WEST SUSSEX COUNTY COUNCIL CONSULTATION

TO:	Arun District Council FAO: Simon Davis
FROM:	WSCC - Highways Authority
DATE:	28 August 2020
LOCATION:	The Cottage Shripney Road Bognor Regis PO22 9PA
SUBJECT:	BE/79/20/RES Approval of reserved matters following BE/63/17/OUT & variation of condition BE/131/18/PL for replacement dwelling at the southern end of site (Phase 1) to reposition driveway & car port (resubmission following BE/58/19/RES).
DATE OF SITE VISIT:	
RECOMMENDATION:	More Information
S106 CONTRIBUTION TOTAL:

Site Plan -
Proposed

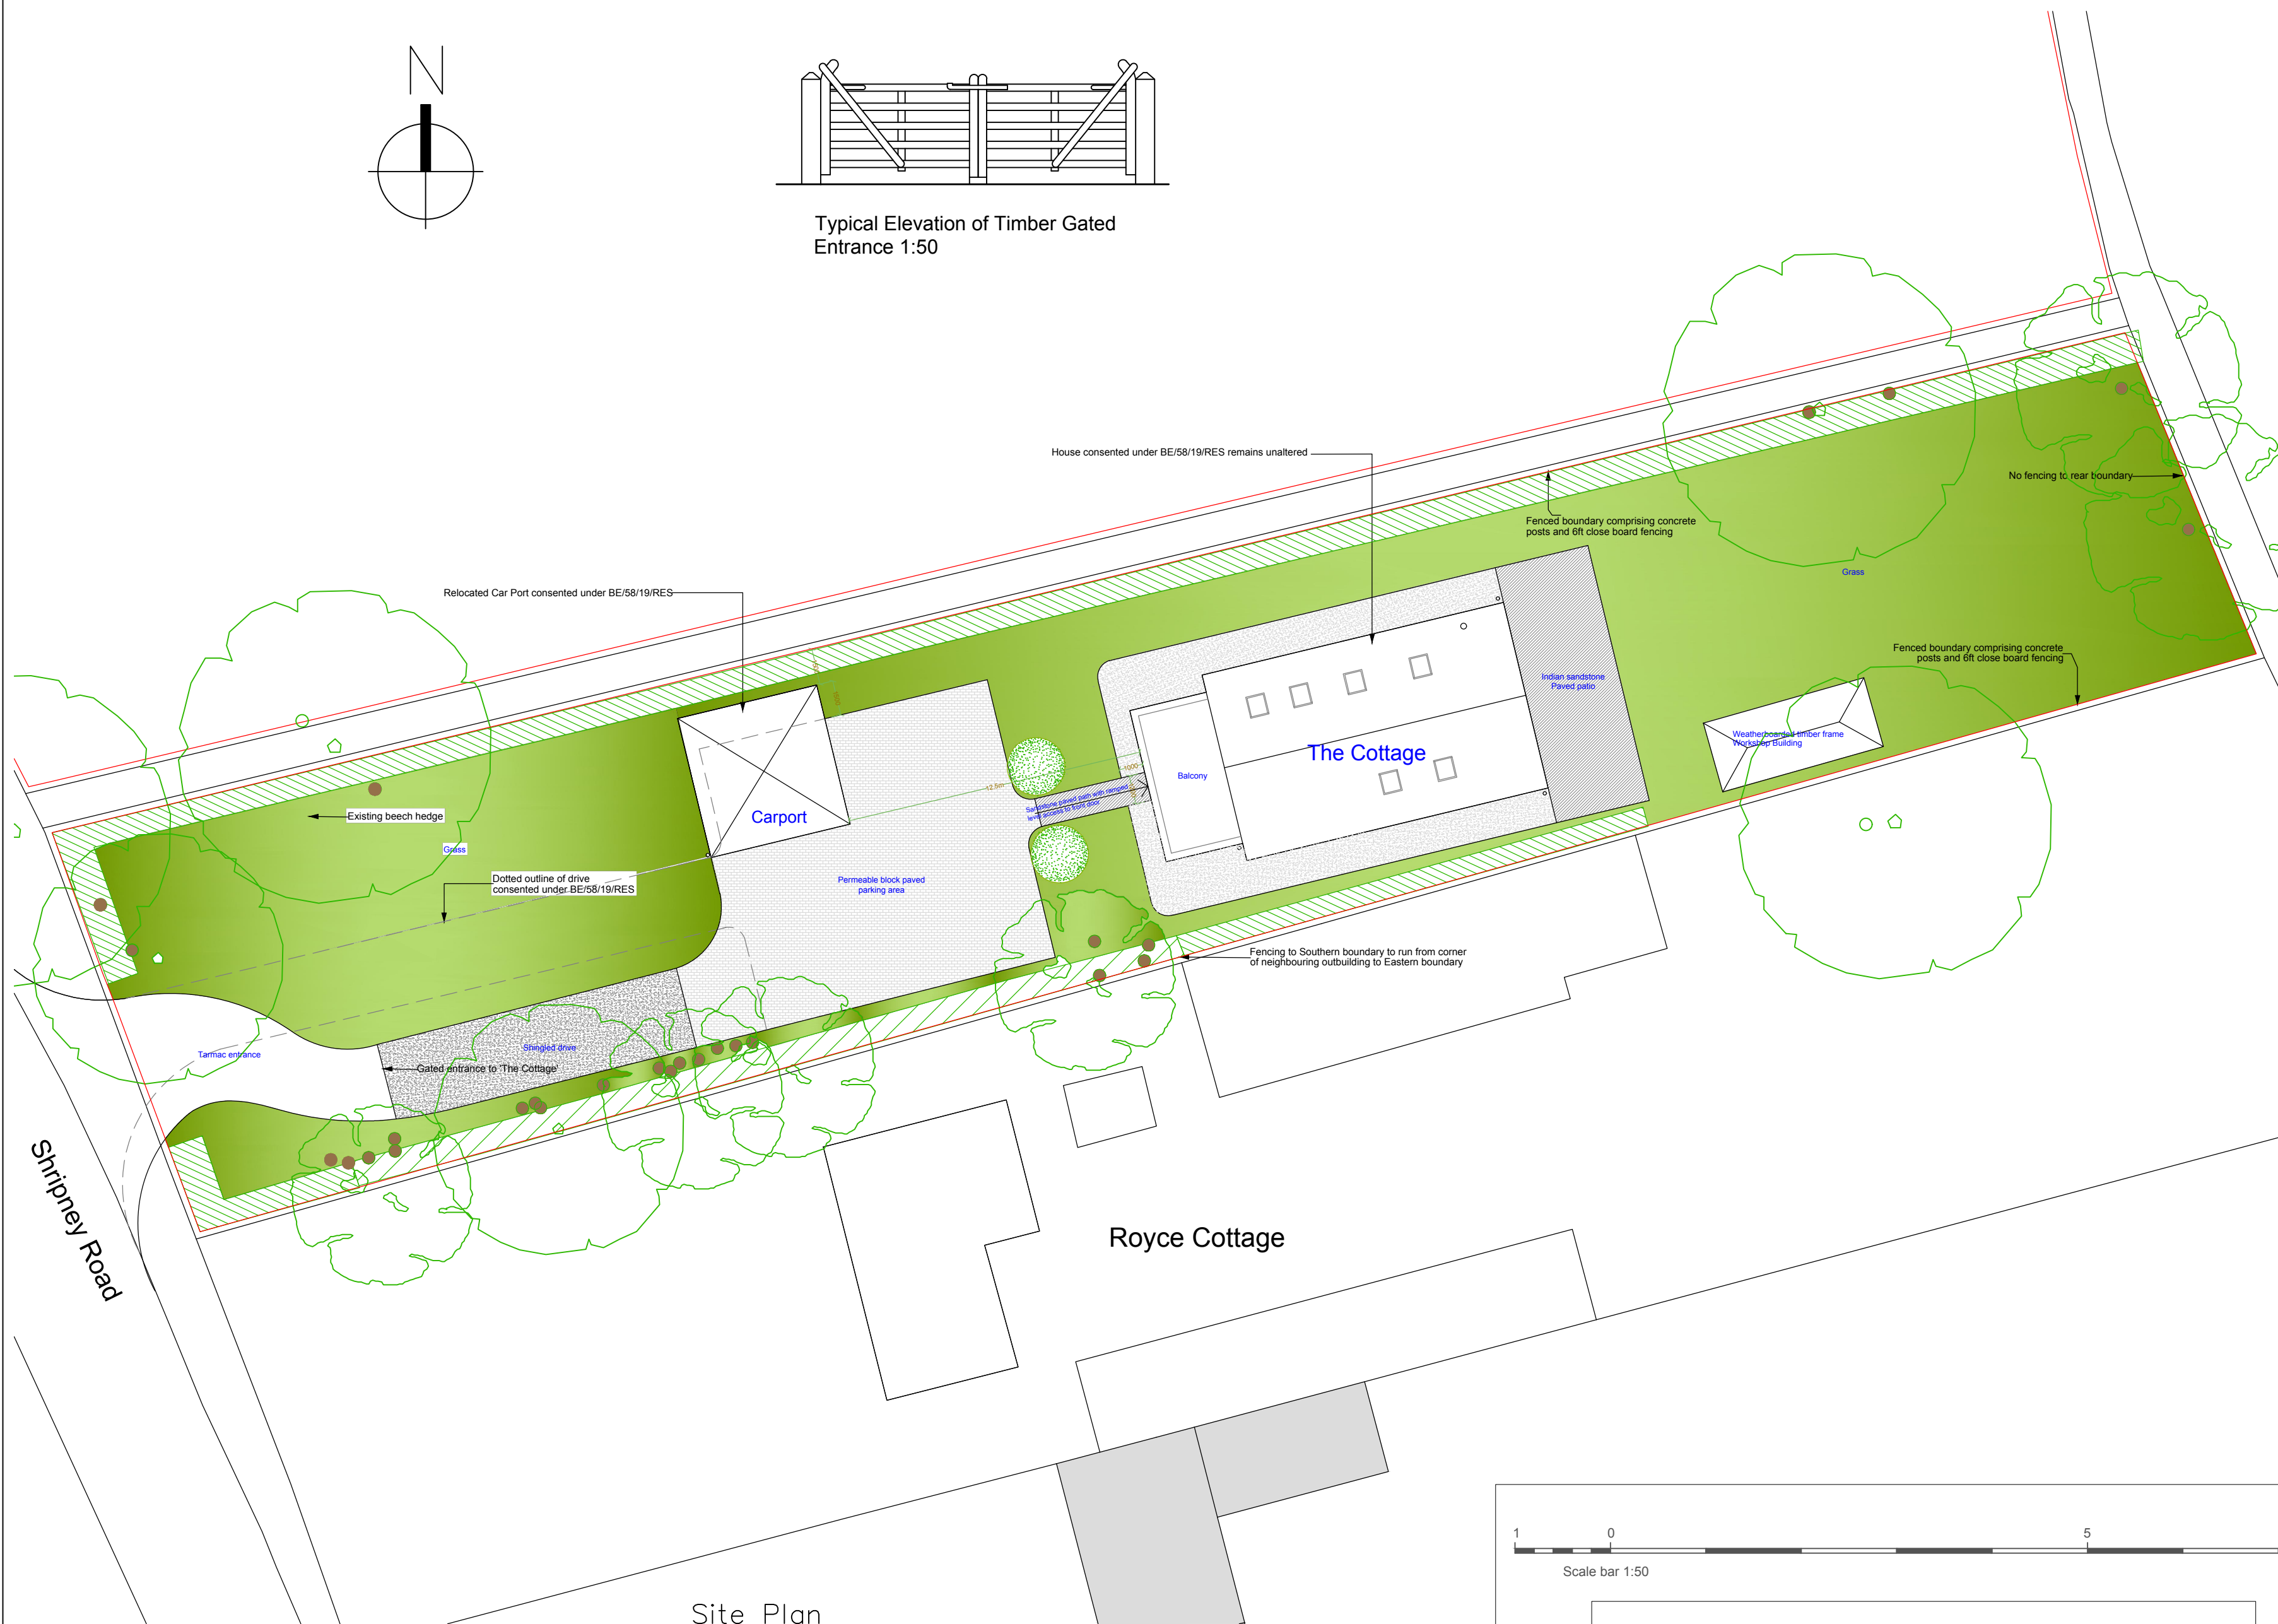
The Local Highway Authority (LHA) has been consulted on the above applicaiton to reposition the driveway and car port. The LHA has previously commented on applications at this site, which made use of an existing access from Shripney Road. It was always the LHA's impression that the access would remain in the same location and just be updated.

The LHA would raise no concern to the internal site driveway layout, nor the position of the gate or car port; however we would need clarification from the developer with regards to the position of the access and if it is or is not moving position?

If the access from the highway is moving position then new drawings to demonstarate this would be required, with access width and new visibility drawings from a 2.4m set back.
